Subject: 2025/62/90439/E, 2025/65/90441/E Church of the Holy Innocents, Vicarage Road, Dewsbury, WF12 9PD

RE: Dewsbury, Church of the Holy Innocents (Grade II, 1858 by *Mallinson and Healey*); Listed Building Consent for conversion of existing listed church to 2 dwellings, forming new residents car park, external amenity spaces and associated works

Thank you for consulting the Victorian Society on this application, I apologise for the delay I submitting these comments. This application was reviewed by the Society's Buildings Committee, a group of architects, historians and heritage professionals. Following their advice we make this **objection** because the proposal would not sustain, conserve, or enhance the significance of the listed building. In our assessment it would cause a high level of less than substantial harm to the significance to the listed building and this harm is not justified

GROUND FLOOR PLAN SCALE 1:100

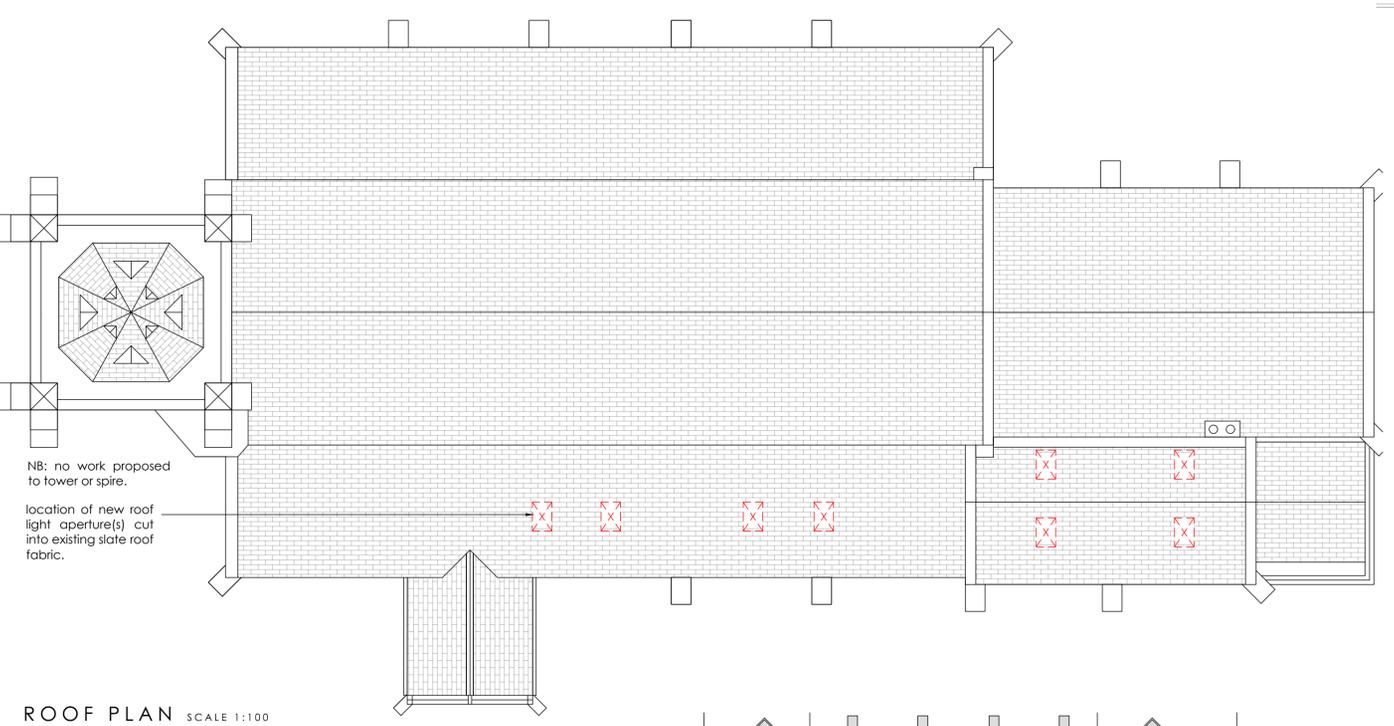
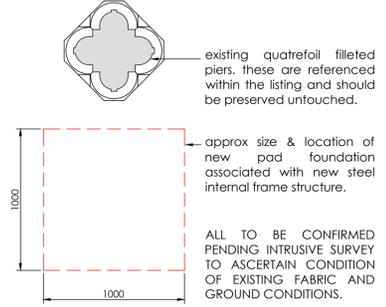
significance of the building as a good example of a substantially complete 19th century church interior, designed by a respected firm of architects. The application contains little detail as to the treatment of the floor, or the impact of the new structure within the building, but a change in floor finishes and structural connections to the fabric have the potential to harm the significance of the building.

PROPOSED PLAN @ FUTURE 1ST FLOOR LEVEL SCALE 1:100
DEVELOPMENT AREA=130 sq.m / 1400 sq.ft

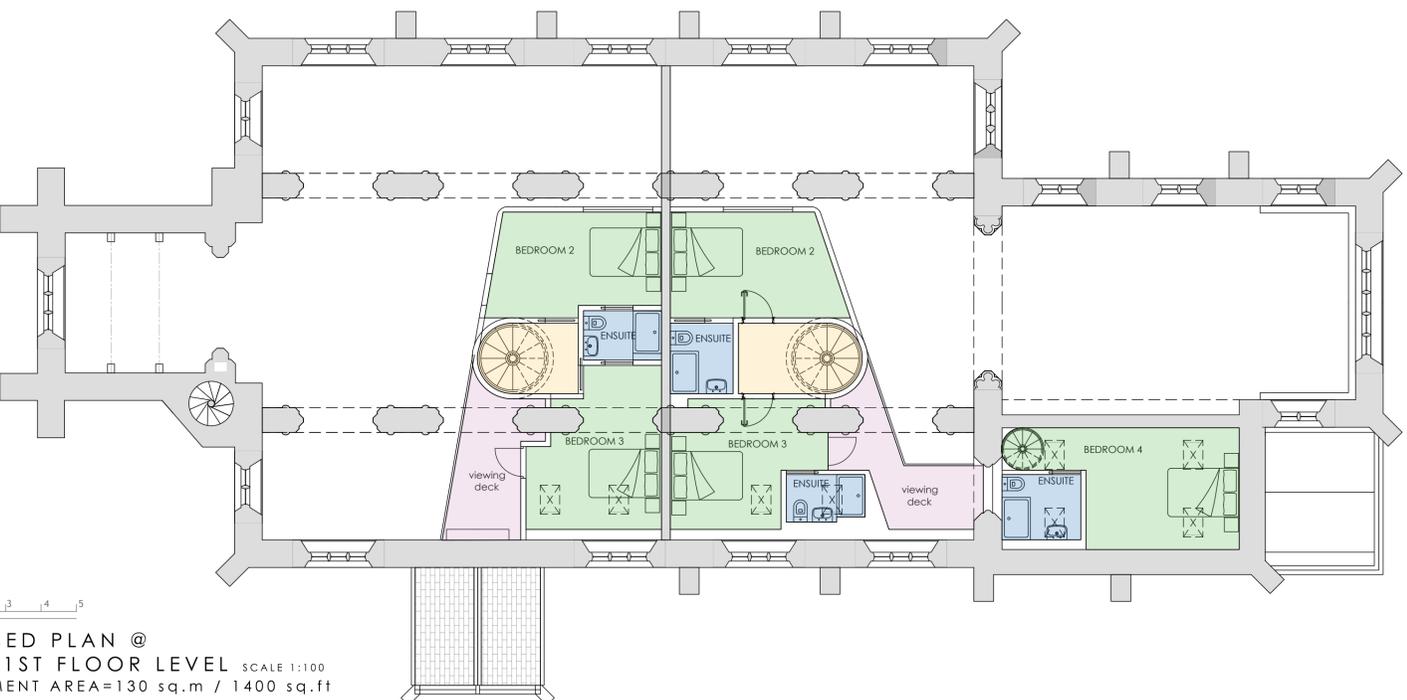
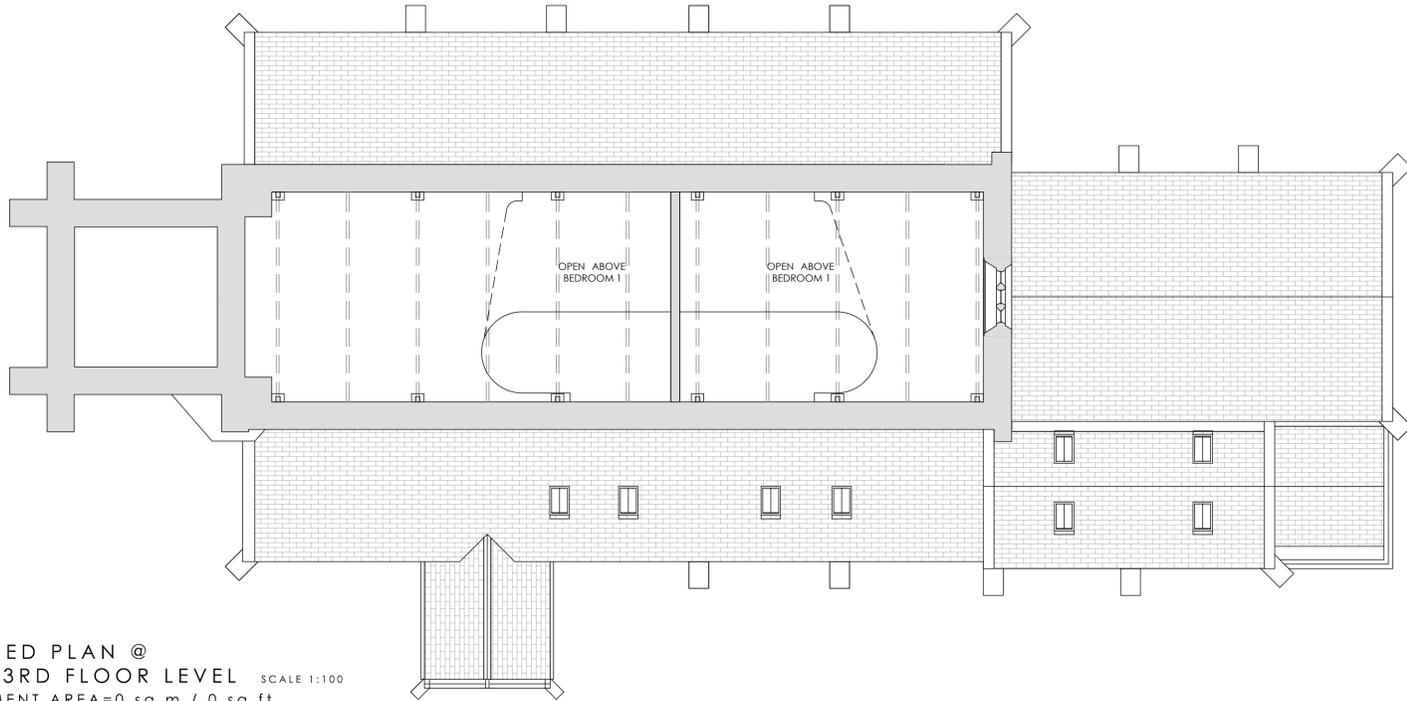
The proposed residential conversion of the building would require the subdivision of the building into no2 units, removing any ability to appreciate the interior volume and character of the space along the principal, east-west axis. This would harm the special interest of the building and its legibility as high-quality Victorian church interior. Although some furnishings such as the font and pulpit would remain, the other fine fittings that are original to the building would be lost. This would also harm the
